Appeal Decisions

Appeal A Ref: APP/R5510/W/22/3310528

89 Warwick Crescent, Hayes UB4 8RQ

Appeal B Ref: APP/R5510/W/22/3313395

DATE	REVISION
COPYRIGHT:	
JOB TITLE:	
89 WARWICK CRESCENT HAYES	
DRAWING TITLE:	
PROPOSED GROUND FLOOR PLAN	
FIRST FLOOR PLAN AND BLOCK / ROOF PLAN	
SCALE: 1:100	
DATE: 21-12-2021	
DRAWN BY:	
REV:	
DWG. NO.	2021/89WCH/03

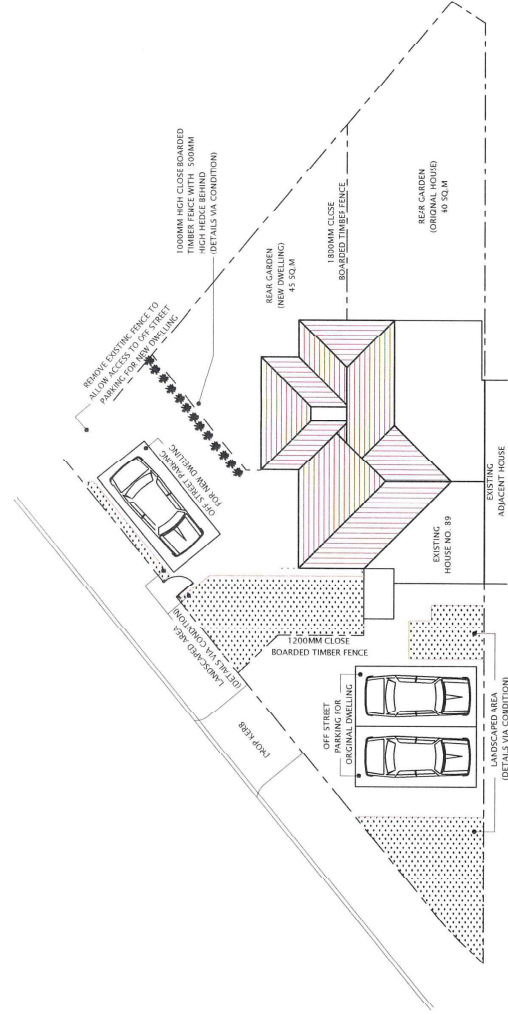
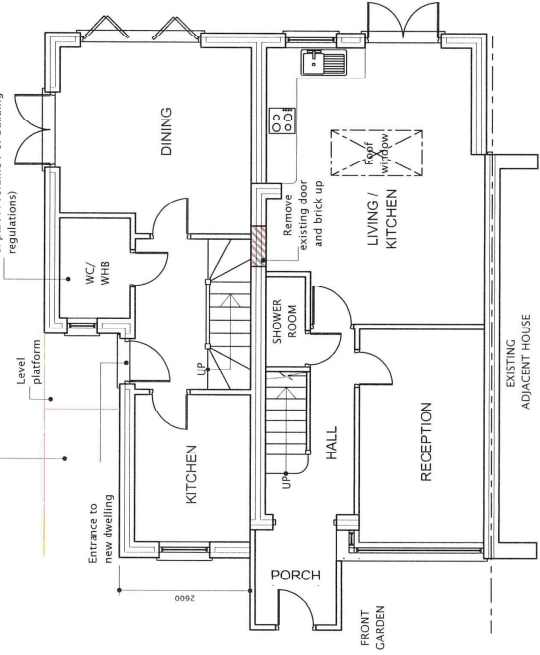
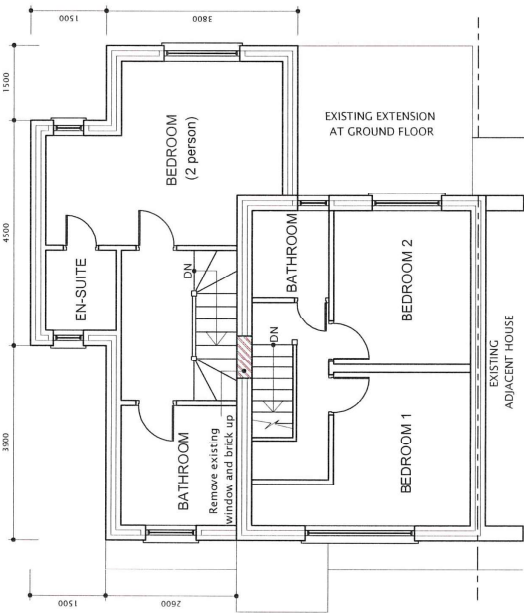
25. The drawings are annotated to show a 'wheelchair accessible ramp', but this would be to a secondary door at the side of the house rather than the principal access. To my mind, this would be rather undignified for a disabled user. Furthermore, there is a lack of any specific detail on its design and layout, as well as how other doors to outdoor spaces would provide step-free access. I have considered whether the matter could be addressed by a planning condition, but I cannot be certain that any works to achieve compliance would not raise fresh considerations, particularly in respect of the external appearance of the development and parking layout. As such, a condition would not be appropriate.
